Reference No:	2024/62/92546/W
Site Address:	3, Greenway, Honley, Holmfirth, HD9 6NQ
Description:	Erection of front porch and front and rear dormers, application of render and alterations (within a Conservation Area)
Recommending Officer:	Molly Storer

DECISION – CONDITIONAL FULL PERMISSION

OFFICER REPORT

North Elevation

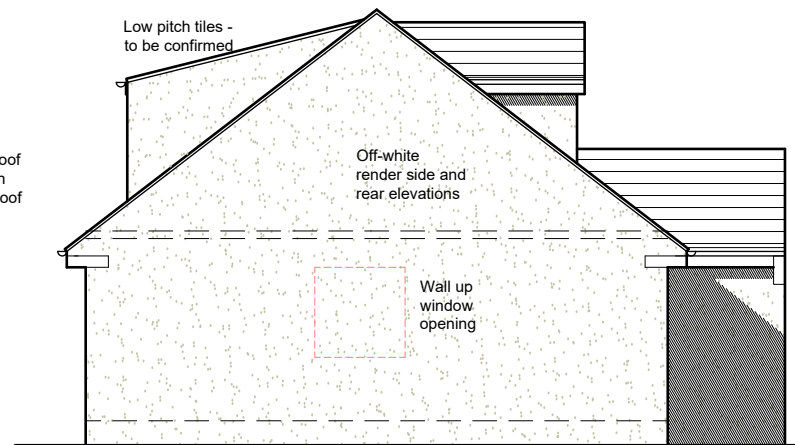
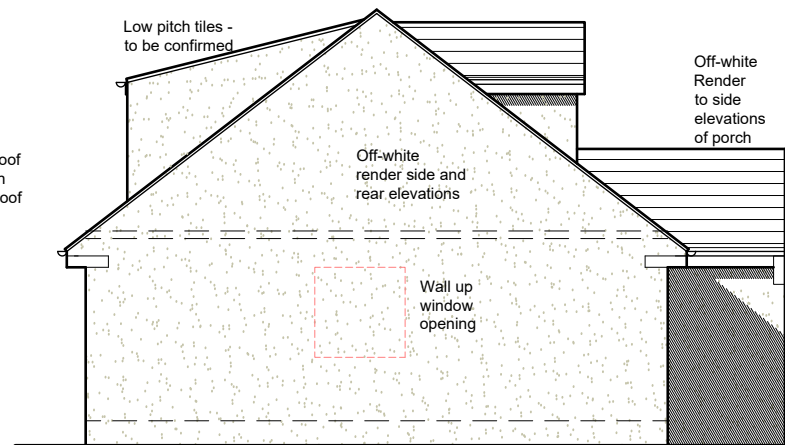
Concerns were raised with the agent it was suggested that consideration should be given to constructing the porch from stone as to maintain the character of the Conservation Area. Amended plans were produced which showed the front elevations of the porch to be constructed from stone with only the side elevations being rendered.

It is considered that white render is seen on other properties within the street scene and amended plans show that the front elevation of the porch and ground floor will still be constructed from stone, as such it is concluded the impact of the development to the Conservation Area would not be harmful subject to condition an off-white colour is used which will have a more neutral tone and appearance.

East Elevation

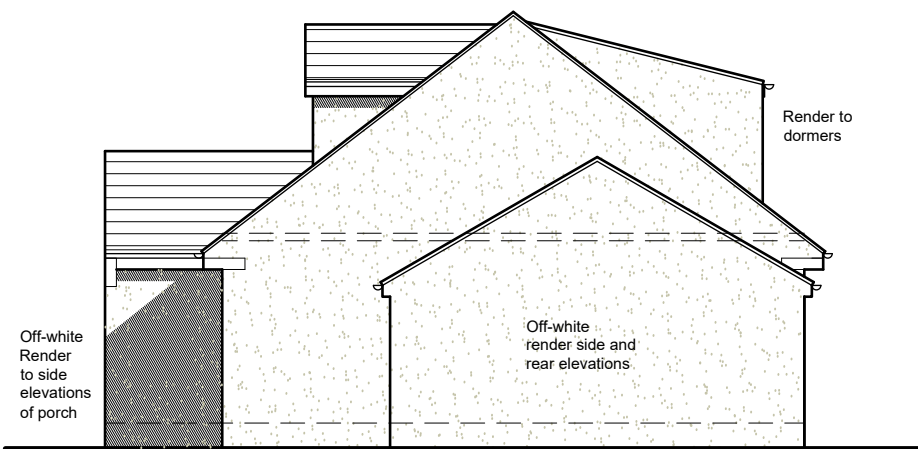
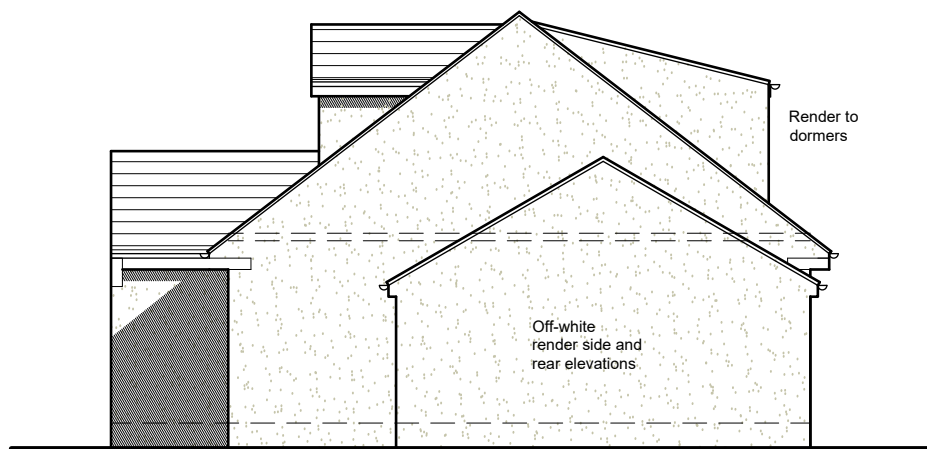
Attention was also brought to the potential impact of the gabled roof of the garage to the neighbouring property. The agent responded with justification which laid out the permitted development fall back option of the ridge that would be 3.8m high and that the neighbour's property is higher than No. 3 and is a distance of 3m away from the gable end. This will be discussed further in the following report.

It is noted that the proposed gabled roof to the extension would create additional massing in close proximity to windows at No.5. However, the footprint of the garage would not increase and it is noted a development to the side could be undertaken through permitted development right.

Notwithstanding this point it is noted further justification has been submitted stating that no.5 is higher than No. 3 and is a distance of 3m away from the gable end.

Having regard to the scale of this element of the proposal and distance from no.5, it is considered that any overshadowing as a result of the additional 1.4m in height would be minimal and refusal on this basis could not be substantiated in this case particularly having regard to the orientation of the site with no.5 being to the west.
